Construction of two storey extension.
Sunny Corner Copse Lane Walberton

Engineer's comments:

Subject: Planning Consultation on: WA/64/12/

(ROOF PLAN ~ AS EXISTING)

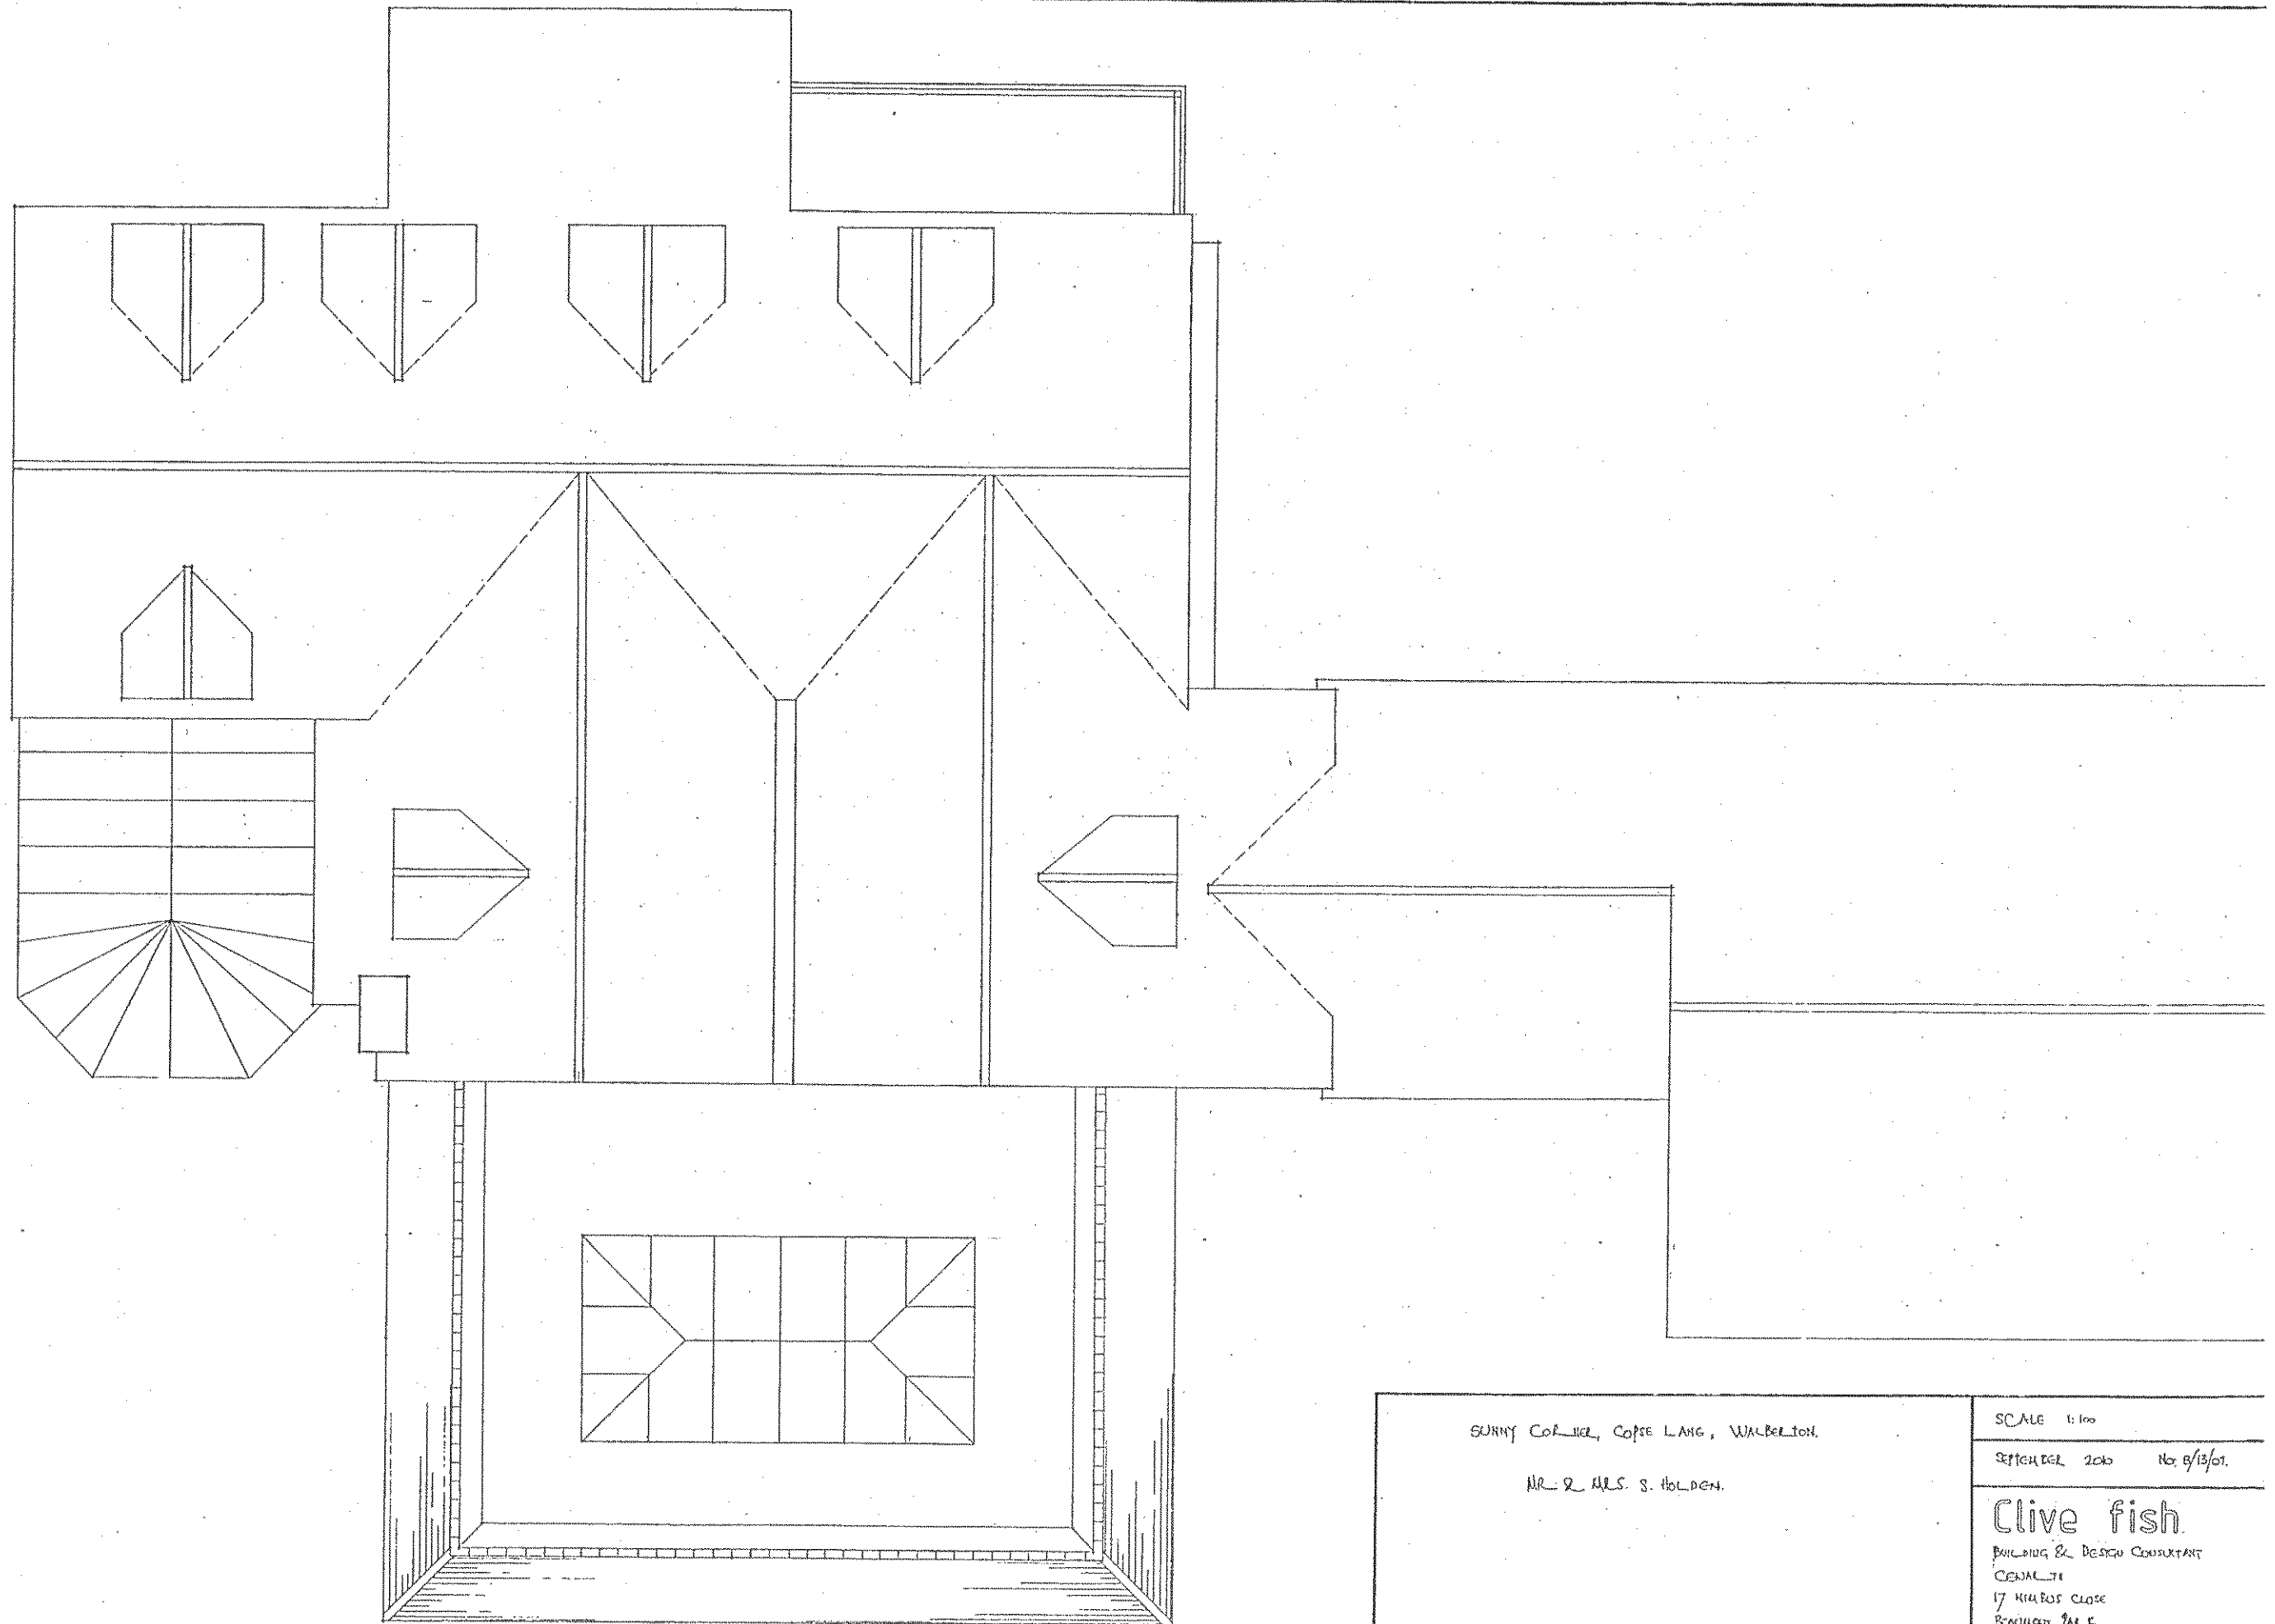
No details are given of the proposed method for disposing of surface water from the extension.

*Details will be required for approval which must not be disposal to the foul sewer.
Standard Condition ENGD2A should be applied.*
